Reference No:	2025/62/90913/E
Site Address:	Gardeners Cottage, Pinfold Lane, Mirfield, WF14 9JA
Description:	Demolition of existing conservatory and erection of two storey extension and outdoor covered oak frame
Recommending Officer:	Nicole Helliwell

Officer Report

Proposal: Demolition of existing conservatory and erection of two storey extension and outdoor covered oak frame.

Proposed South Elevation

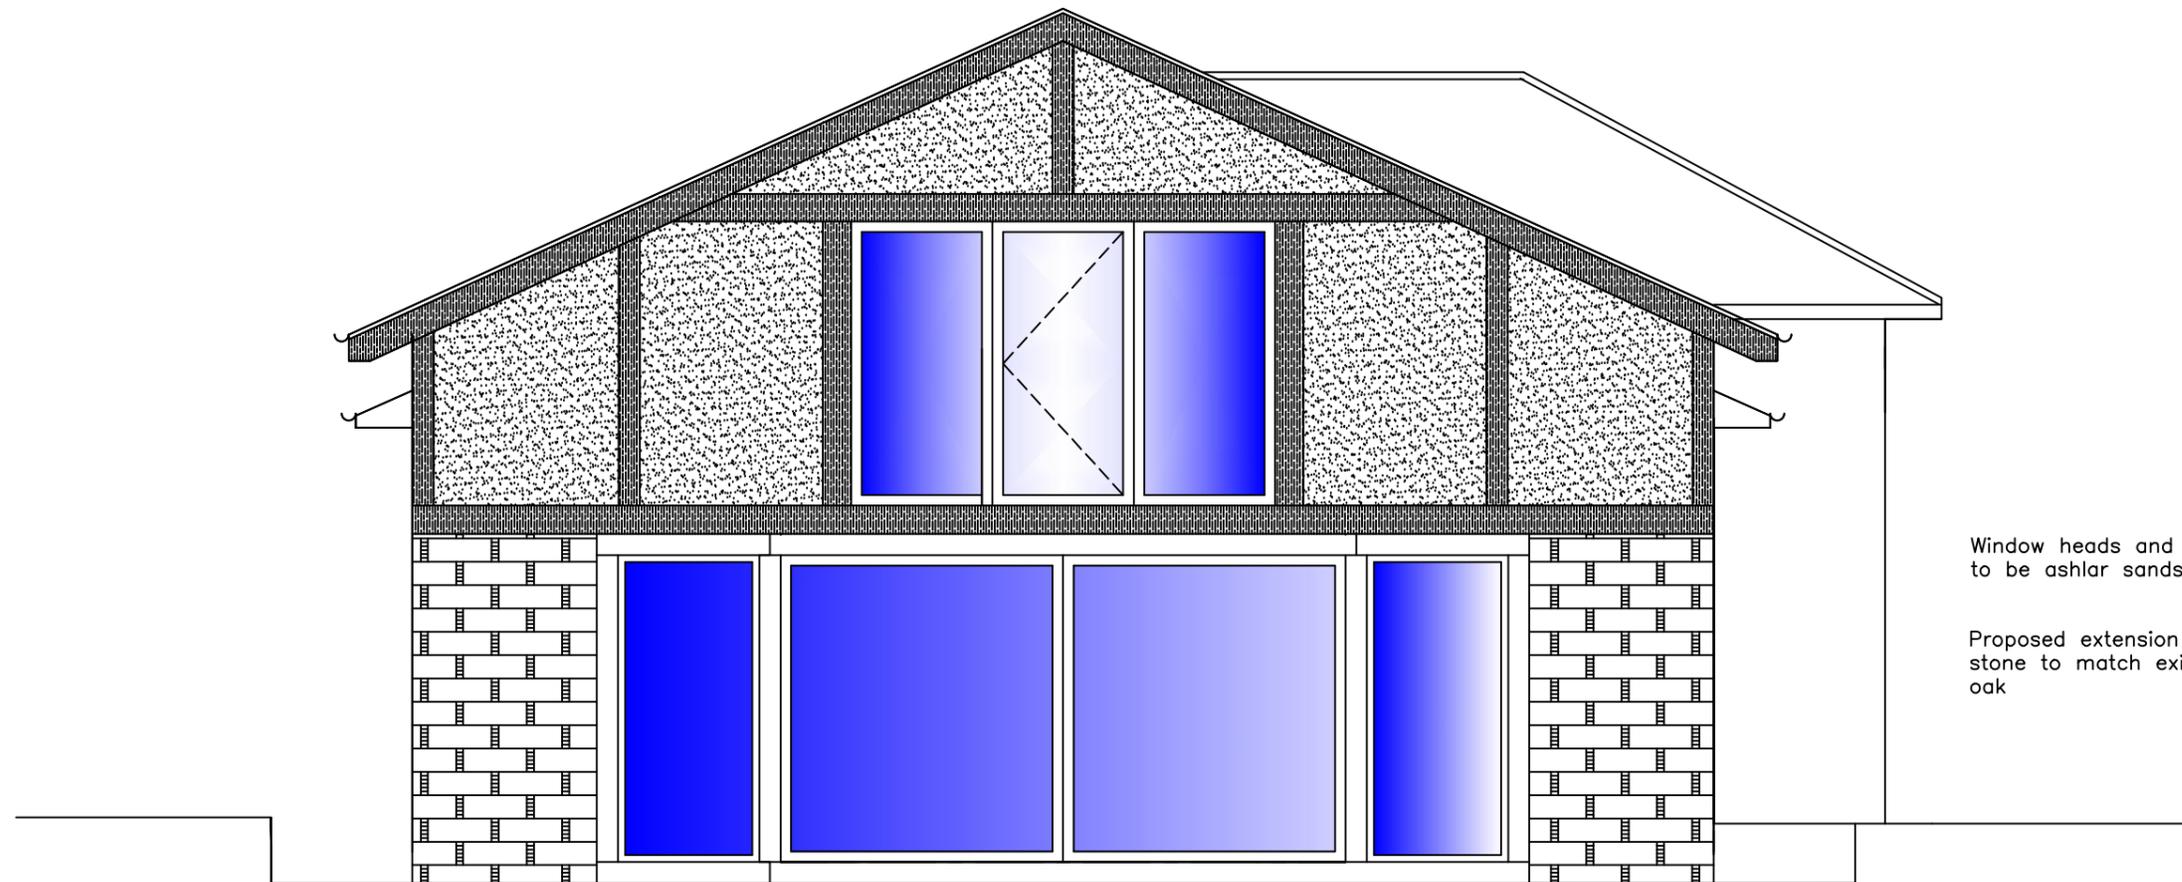
The proposed two storey extension would project approx. 4.37m from the south elevation of the original build. The enlargement would be constructed from stone at ground floor level with render and oak at first floor level and would incorporate a dual-pitched roof finished in stone tiles. The enlargement would feature a high ridge line and would lack subservience to the original build. The extension would alter the scale and form of the original build and due to its incongruous design would fail to integrate with the host dwelling. On this basis, it is considered that the proposal would unduly harm the character and

appearance of the host property and surrounding area and cannot be supported in terms of visual amenity.

1. The proposed two-storey extension by virtue of its design and scale would lack subservience and would appear disproportionate in relation to the original dwelling. The extension would fail to harmonise with the existing dwelling and the character and appearance of the wider area. To permit the proposal would be contrary to Policy LP24 of the Kirklees Local Plan, the House Extensions and Alterations SPD and Chapter 12 of the National Planning Policy Framework.

Proposed elevations of oak covered garden frame

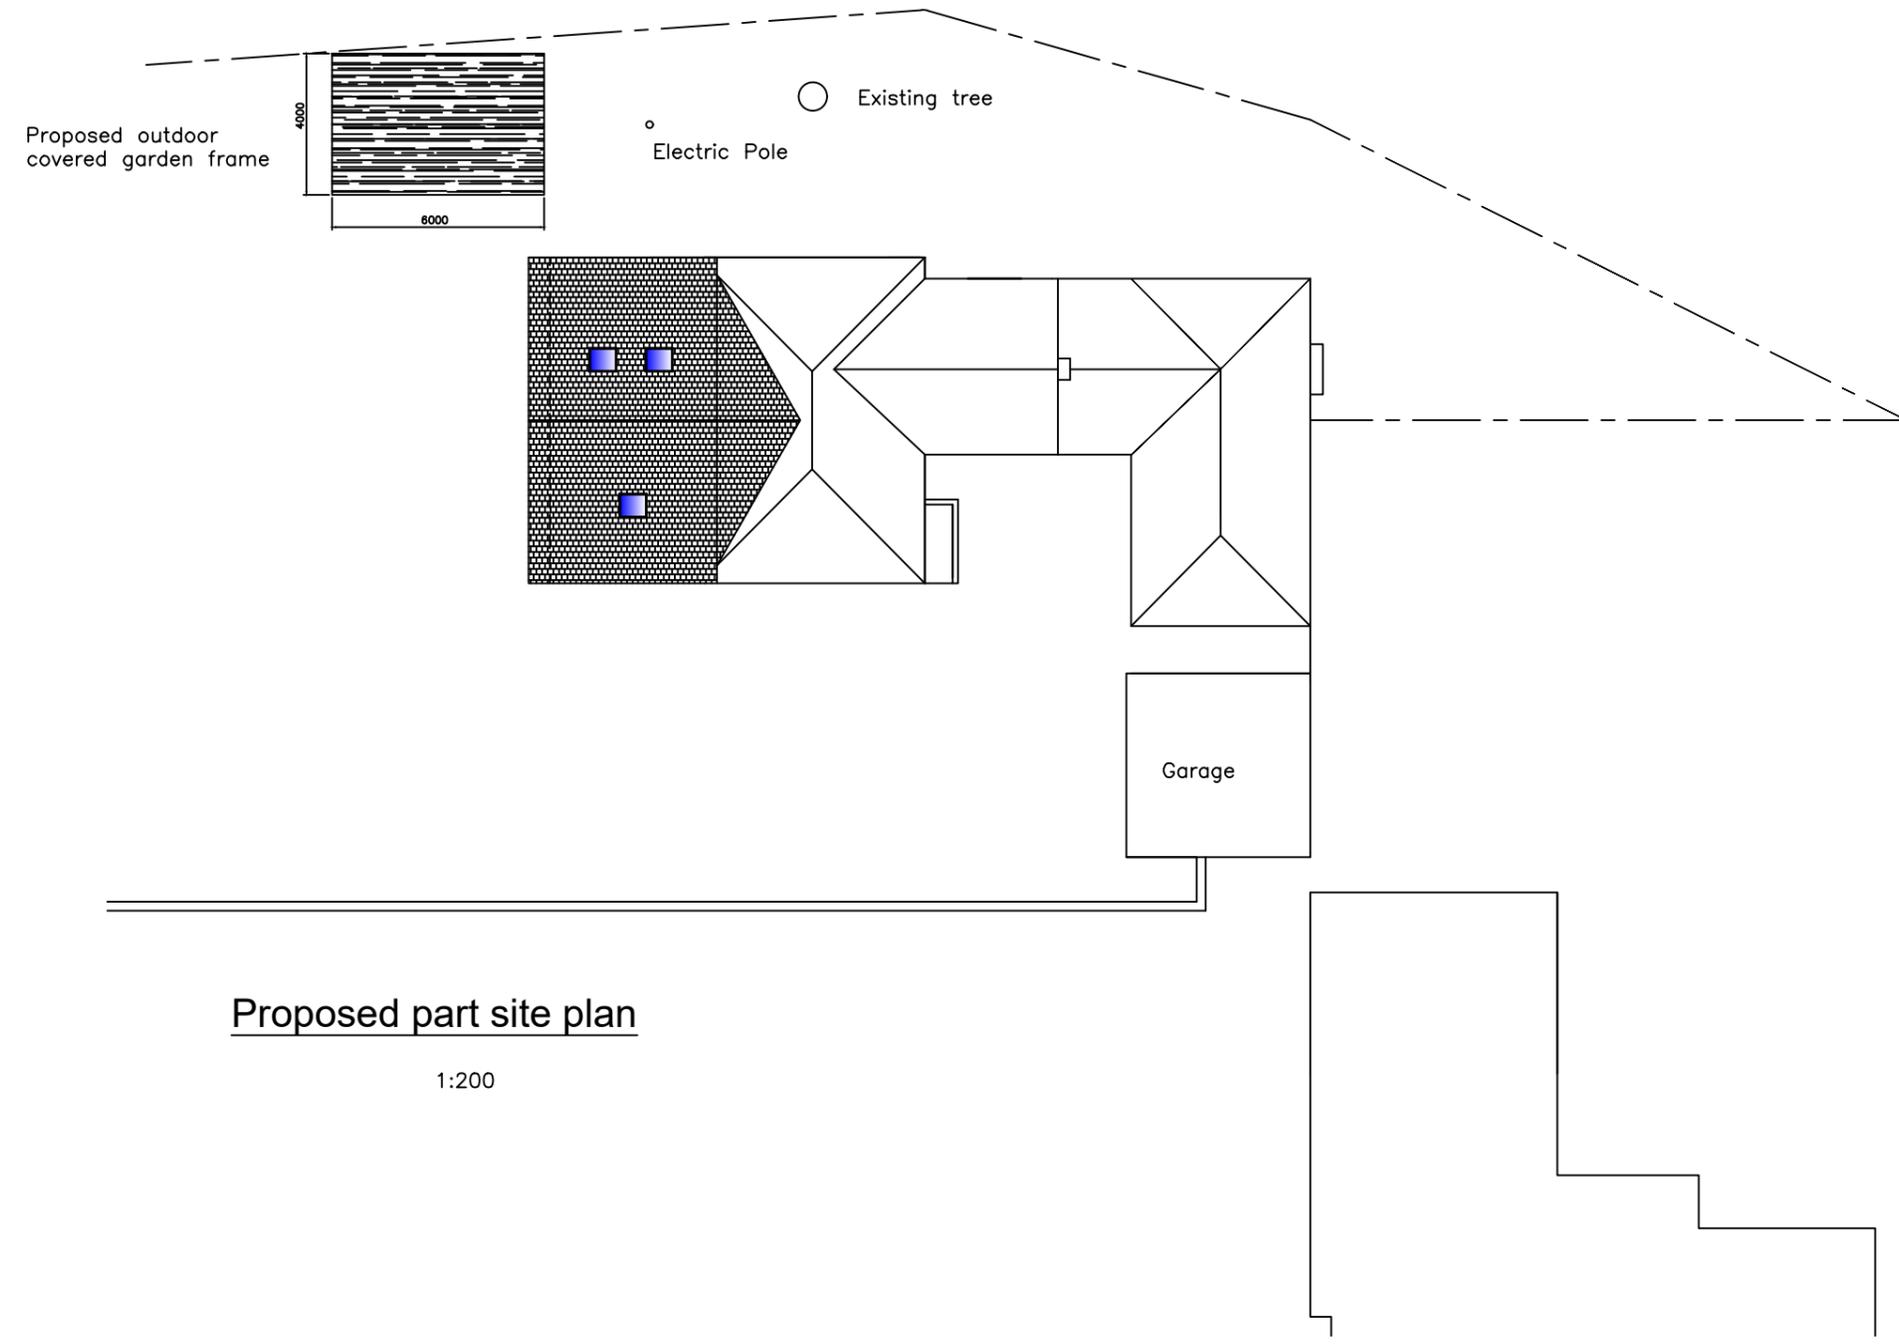
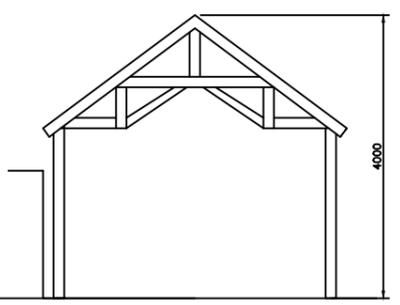
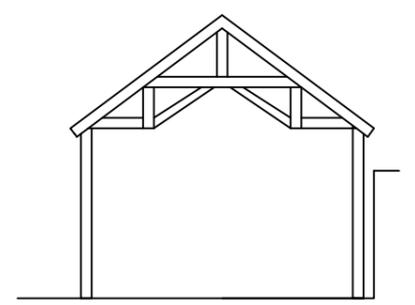
The frame proposed would measure 6m in length, 4m in depth and 4m overall in height. The structure would be constructed from oak with a roof covering. Although it is noted that the outbuilding would be sited forward of the original building line, the structure would not be unduly prominent within the street scene given the siting of the dwelling. On this basis, the proposed development would respect the visual amenity of the host property and wider street scene and would be acceptable.
